Response to Planning application from Hertfordshire County Council (T and CP GDP Order 2015)

District ref: 6/2022/2893/COND
HCC ref: WH/15175/2022
HCC received: 30 December 2022
Area manager: Manjinder Sehmi
Case officer: Senober Khan

Submission of details pursuant of Condition 1 (Gosling Sports Park Car Park) Condition 6 (Construction Traffic Management Plan) Condition 7 (Haul Road (fencing, gates and final materials) Condition 9 (Car parking – disabled access) Condition 17 (Phase 2 Disabled Access) on planning permission 6/2021/2125/MAJ

Figure 1 – Annotated extract from plan no. HCHQ-VGA-XX-XX-DR-AR-00140-PL02

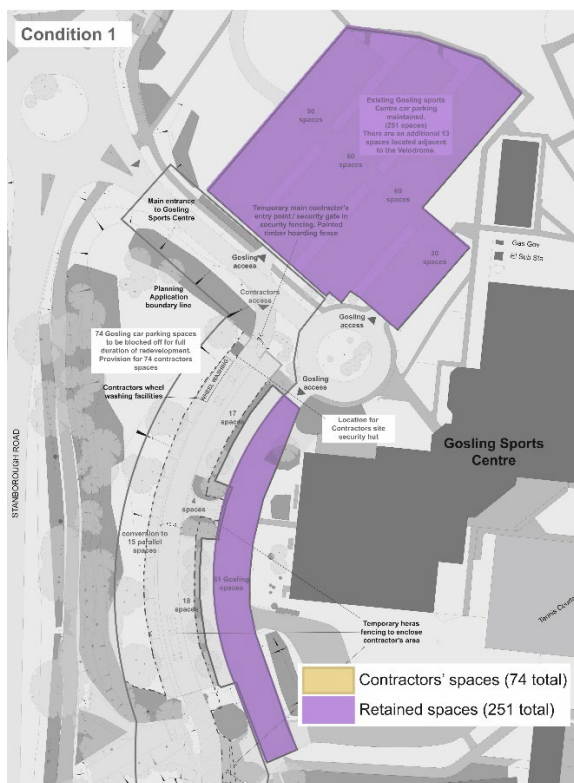
To provide access for the Main Contractor construction vehicles during the development of the Herts Police HQ project, the Gosling Sports Centre (GSC) have agreed to allow access through an area of their site (See the approved planning application drawing reference AR-00118 Rev:PL02).

Drawing identifies 74 car park spaces that have been allocated to the Herts Police's Main Contractor throughout this construction phase of the project.

The HA is satisfied that the use of this area for the construction period would not negatively impact on the users of the Gosling Sports Centre and there would be sufficient car parking available elsewhere to not create any nuisance or parking hazard on the public highway or other users.

The HA is satisfied that conditions 1 and 6 can be discharged
